## WEST SUSSEX COUNTY COUNCIL CONSULTATION

<b>TO:</b>	Arun District Council FAO: Hannah Kersley
<b>FROM:</b>	WSCC – Highway Authority
<b>DATE:</b>	28 January 2026
<b>LOCATION:</b>	Phase 6a Hampton Park Littlehampton
<b>SUBJECT:</b>	LU/249/25/RES Approval of reserved matters following LU/47/11/ (amended by LU/182/15) comprising 288 No residential dwellings, the formation SUDs features, children's play space, landscaping, car parking, roads, landscaping and public access to the northern extent of the Black Ditch Open Space.
<b>DATE OF SITE VISIT:</b>	n/a (desktop study undertaken as site visited previously)
<b>RECOMMENDATION:</b>	More Information Required

scheme: Hampton Park
Littlehampton
client: Persimmon Thames Valley
drawing: Hard Landscape
date: November 2025
scale: 1:200@A1
drawing no: PERTV24807 14 - Sheet 3 of 11
drawn: RP checked: RH

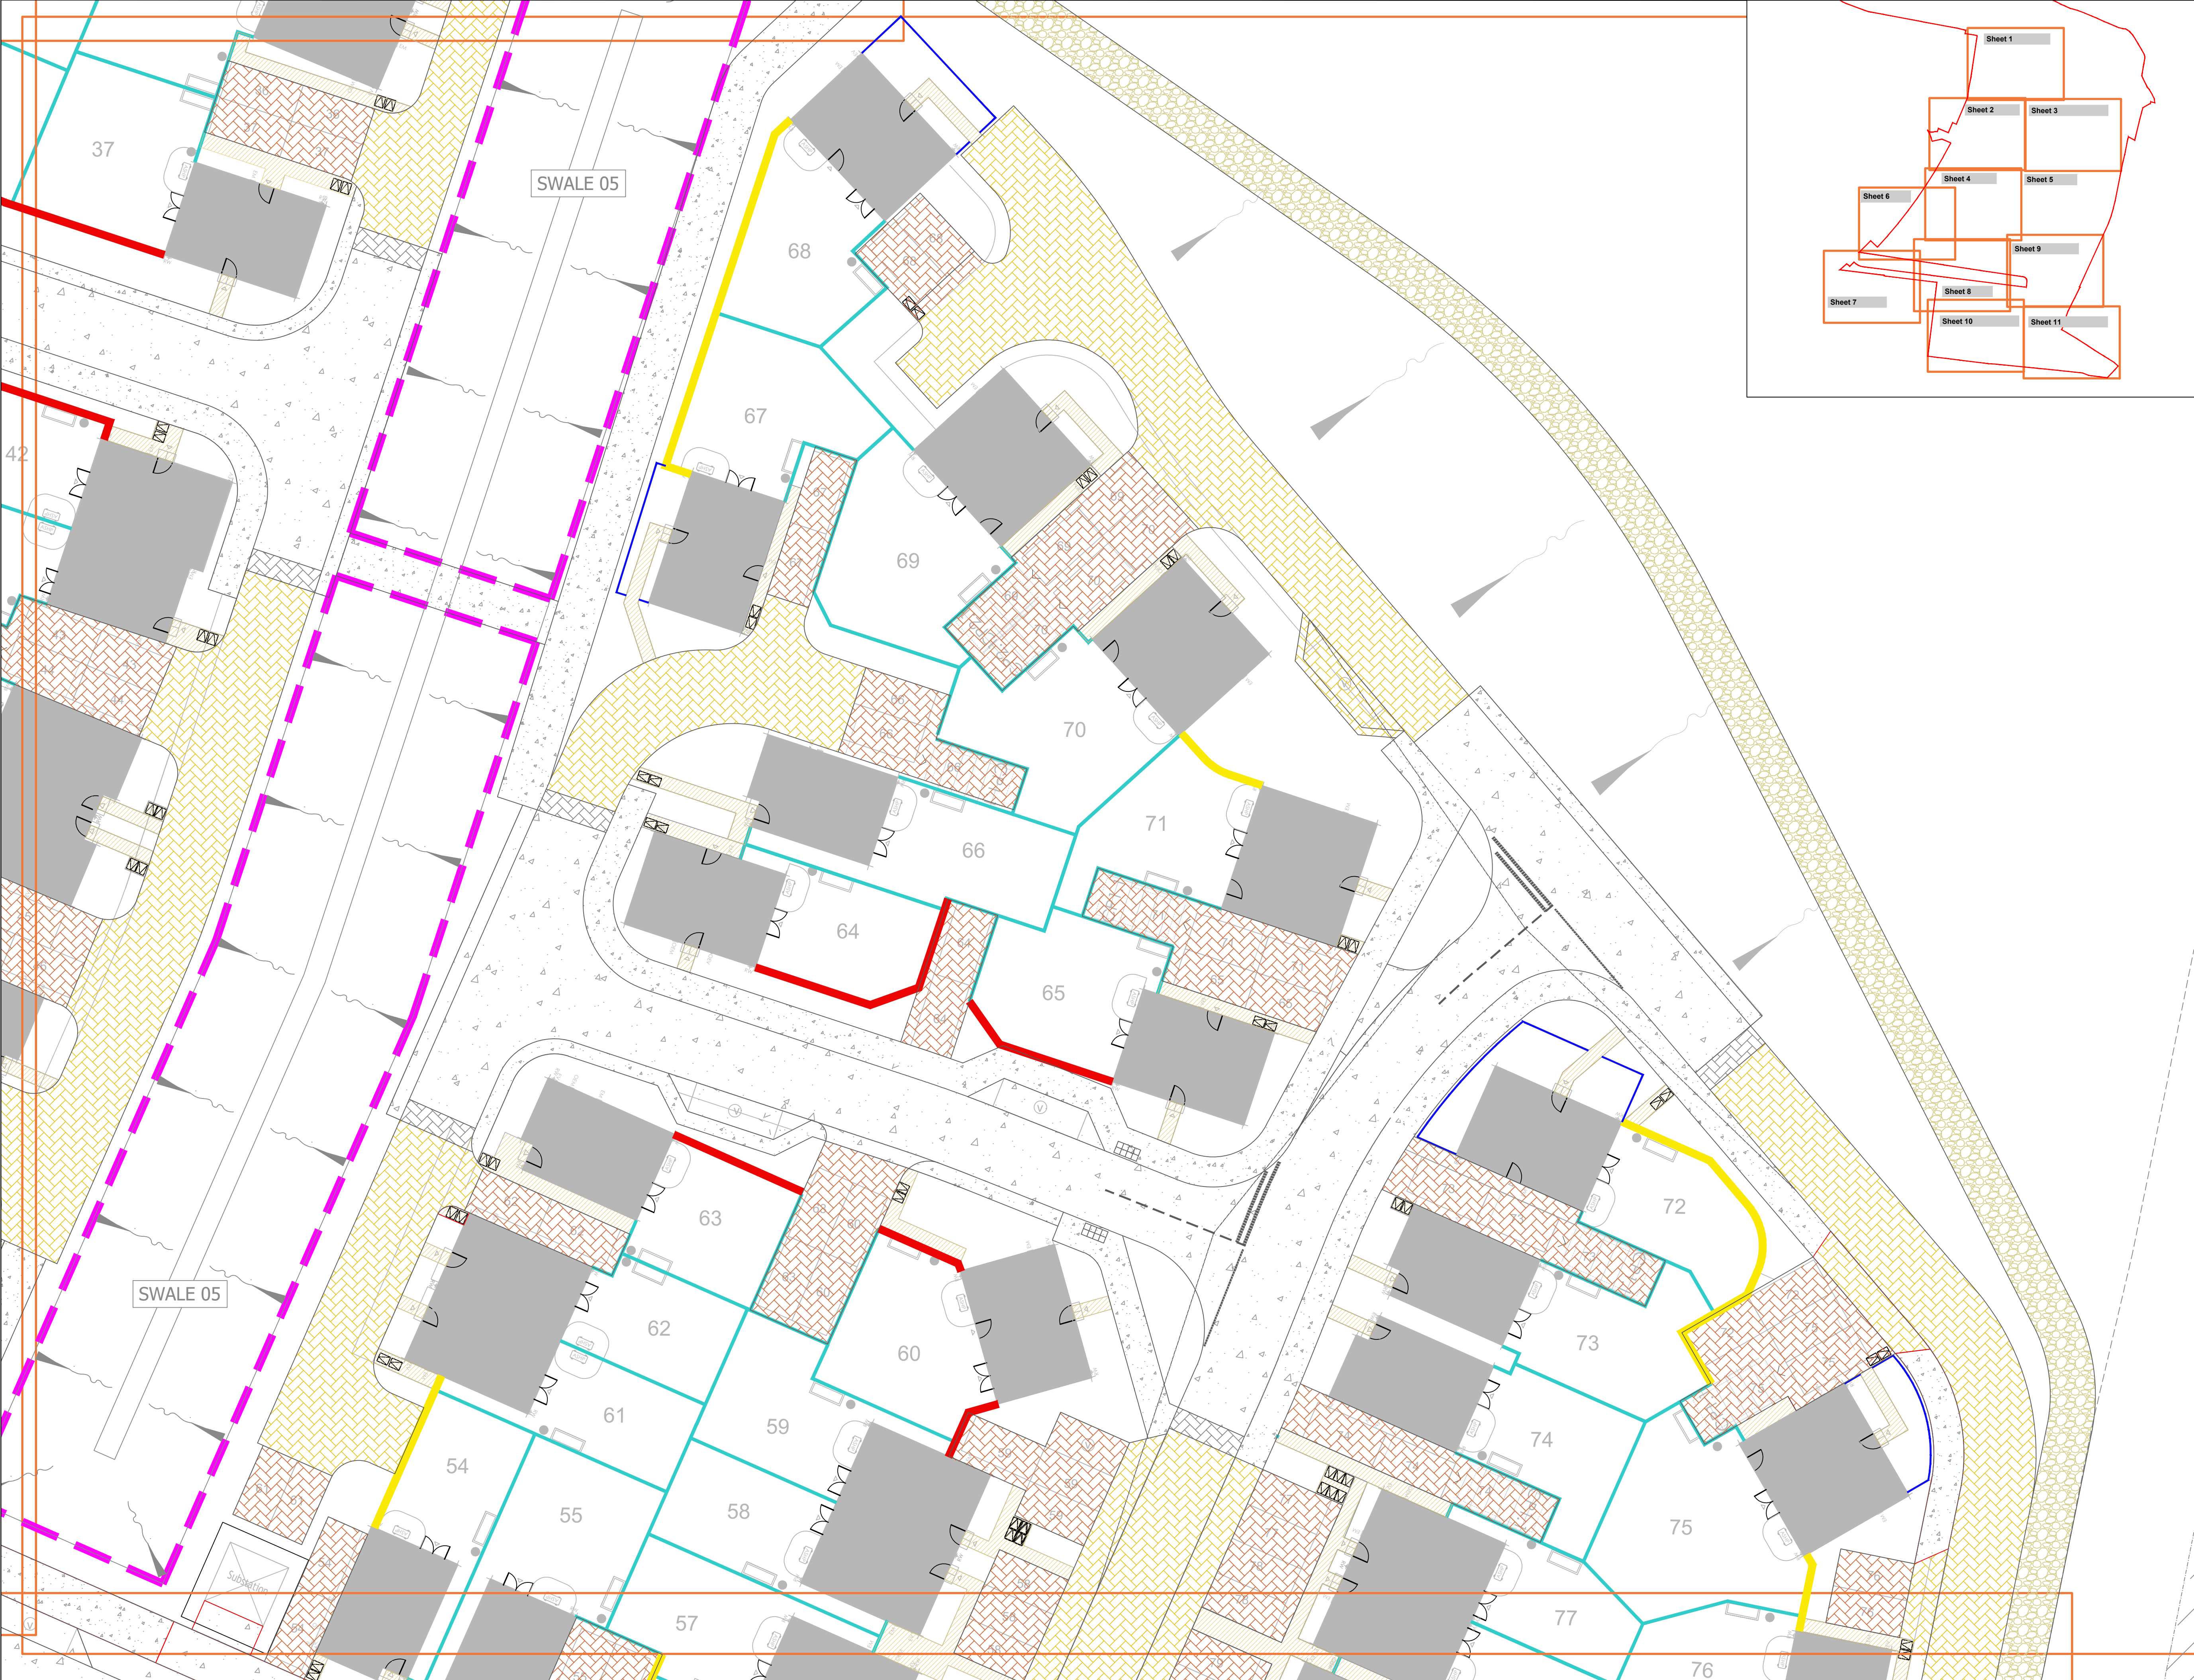
- Tree selection: *Malus 'John Downie'* should be avoided near to footways of carriageways which are to be proposed for highway adoption due to fruiting abundance and relating future nuisance concerns.
- Hedgerow planting will not be acceptable for highway adoption due to ongoing maintenance requirements (sheet 3, x2 locations).
- Planting should not obstruct forward visibility of junctions (sheet 3, x1 hedgerow).

**Figure 1 – Screenshot of sheet 3: Annotated to show hedgerows within areas likely to be offered for highway adoption and containing hedgerow planting (note the northern hedgerow is within the assumed indicative visibility splay shown). Hedgerow to be removed from the plans.**
